PLANNING CONSULTATION RESPONSE

Application No	<u>2026/0342</u>
Proposal	Amalgamation of two semi-detached properties to create a single dwellinghouse, with front gable extensions and dormer window; and associated alterations.
Address	2 St John's Close, Dodworth , Barnsley, S75 3RY
Date of Consultation Reply	10/06/26
Consultee	Highways Development Control

Proposed Site Plan
Scale 1:200

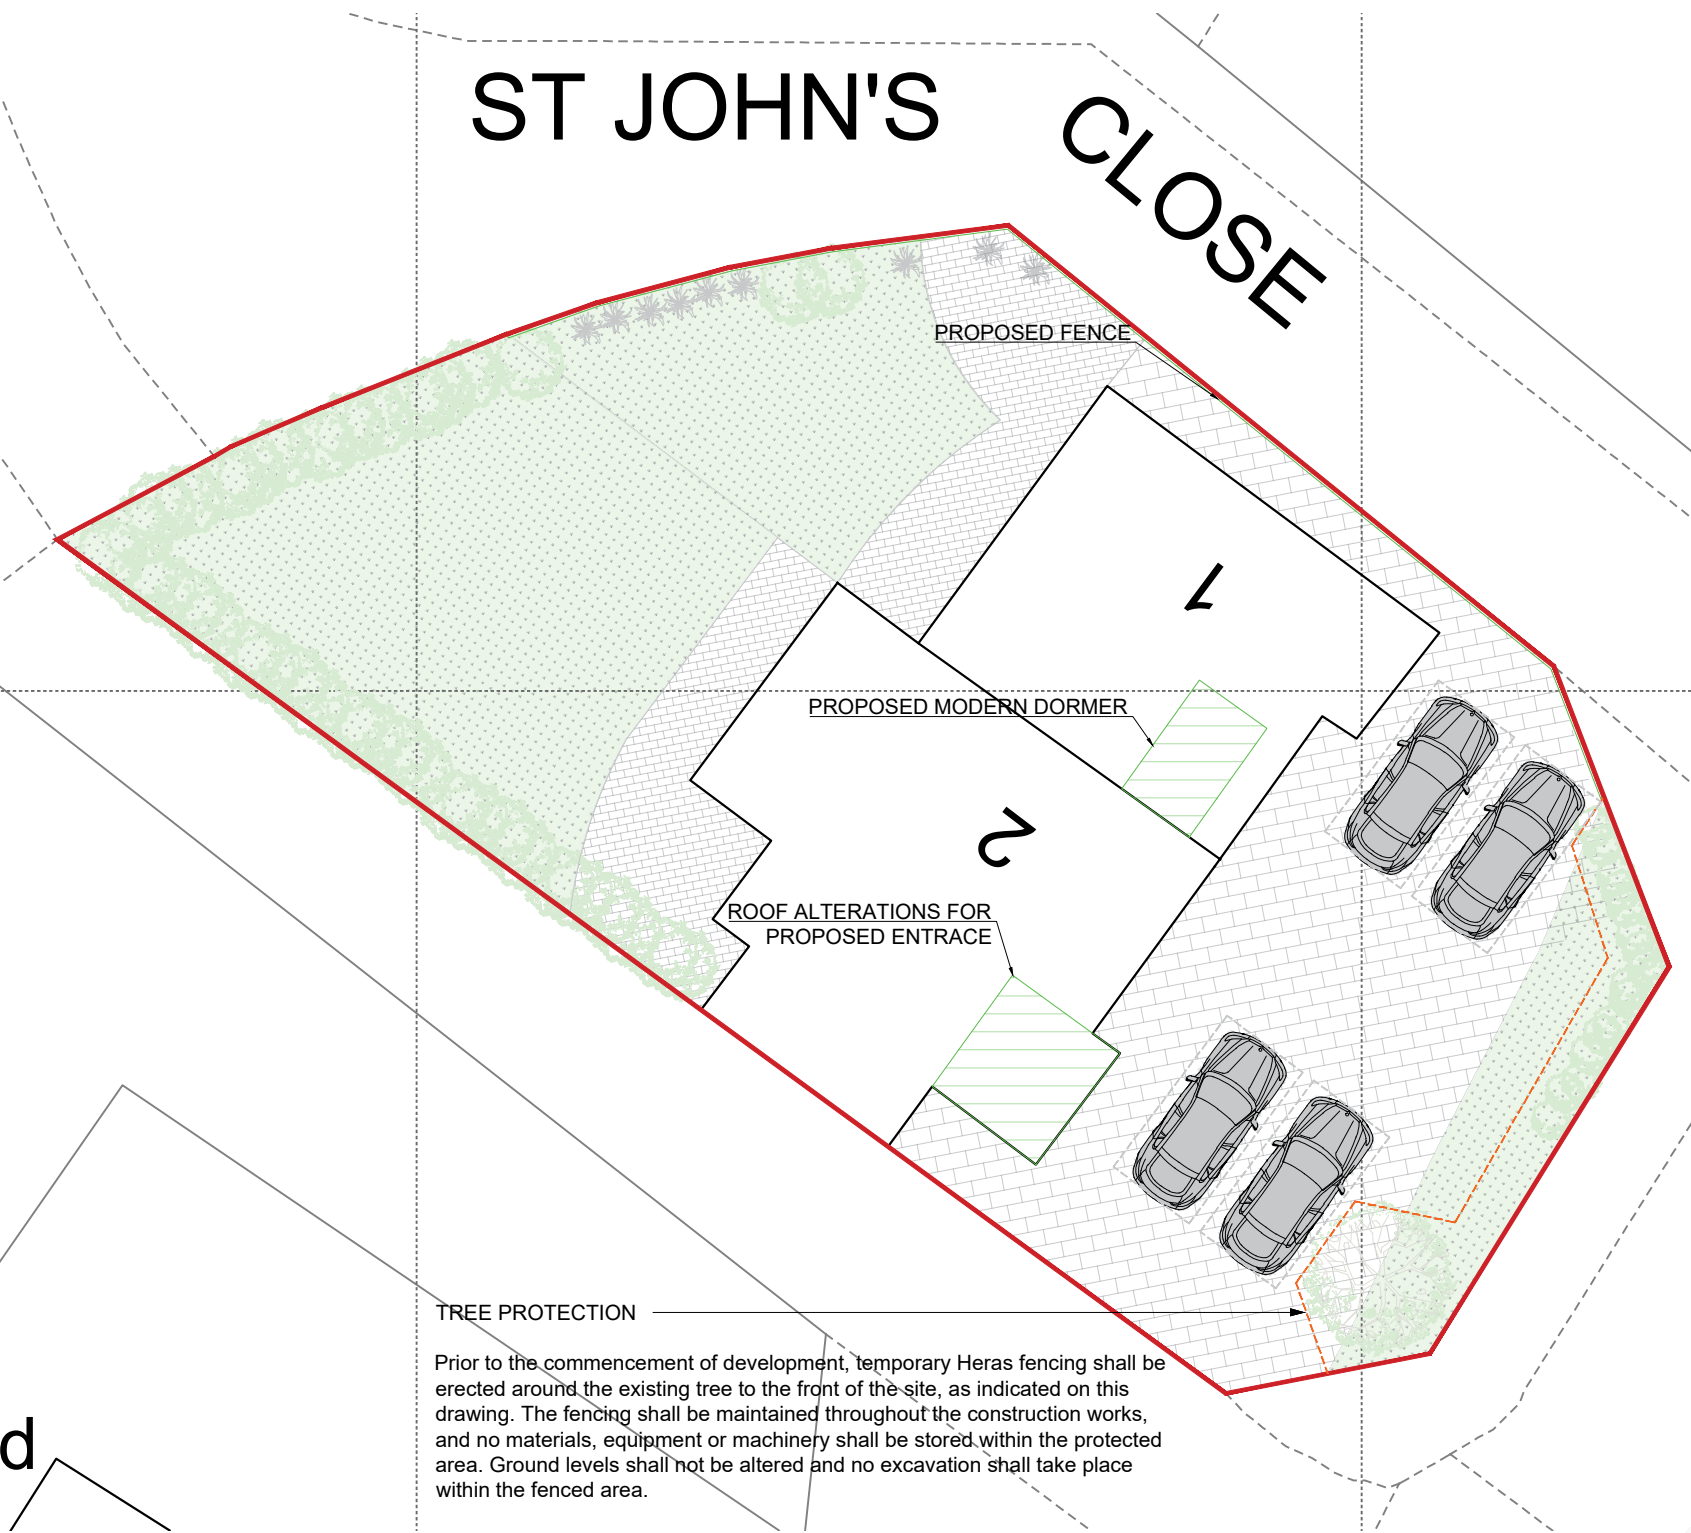
I note from the Design and Access Statement that the existing access arrangements are to be retained, with the loss of the garage at No. 1 St John's Close. It is also noted that this property does not appear to benefit from a forecourt capable of accommodating off-street parking. No. 2 St John's Close appears to provide a forecourt of approximately 7.5m to the front, together with what appears to be potential side access for additional parking.

However, in the absence of a site plan clearly identifying the red line boundary and corresponding parking provision, it is not possible to confirm that the proposal would meet the required standard of two in-curtilage parking spaces.

I would therefore be grateful if the applicant could provide further details to demonstrate the parking provision available to serve the amalgamated dwelling.
